WEST SUSSEX COUNTY COUNCIL CONSULTATION

TO:	Arun District Council FAO:Michael Eastham
FROM:	Stephen Gee WSCC - Highways Authority
DATE:	13 May 2019
LOCATION:	Land east of Tye Lane Walberton
SUBJECT:	WA/11/19/DOC Approval of details reserved by condition imposed under ref WA/44/17/OUT relating to Condition Nos 15 layout & specification of & construction programme roads, footpath, cycleways and parking areas, 19 fire hydrants and 23 air quality & noise impact assessments. Revised plans received.
DATE OF SITE VISIT:	
RECOMMENDATION:	No Objection
S106 CONTRIBUTION TOTAL:	£ See below for breakdown.

My comments focus on condition 15 relating to the layout & specification of & construction programme roads, footpath, cycleways and parking area.

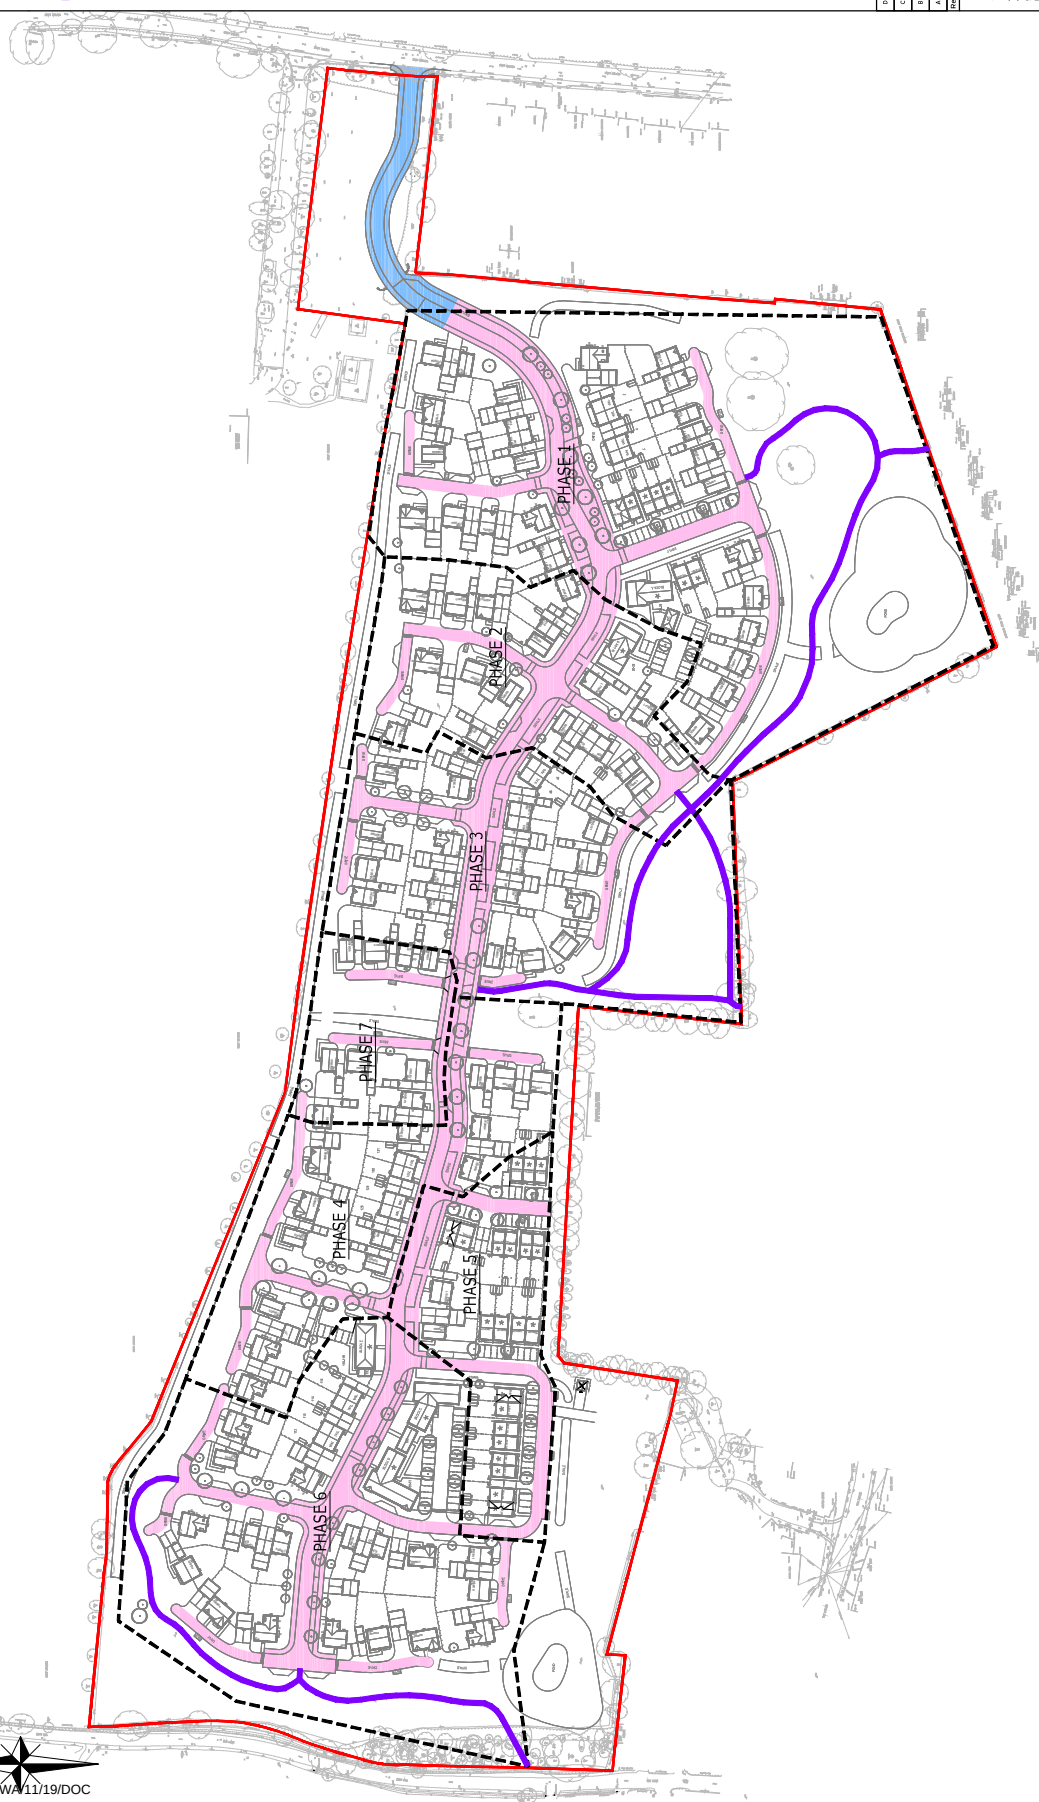
No objection is raised to the discharge of condition 15 (Layout & specification of & construction programme roads, footpath, cycleways and parking areas) following the provision of drawing ref 183240-008 rev D detailing the proposed construction phasing plan which now includes the pedestrian links to be provided.
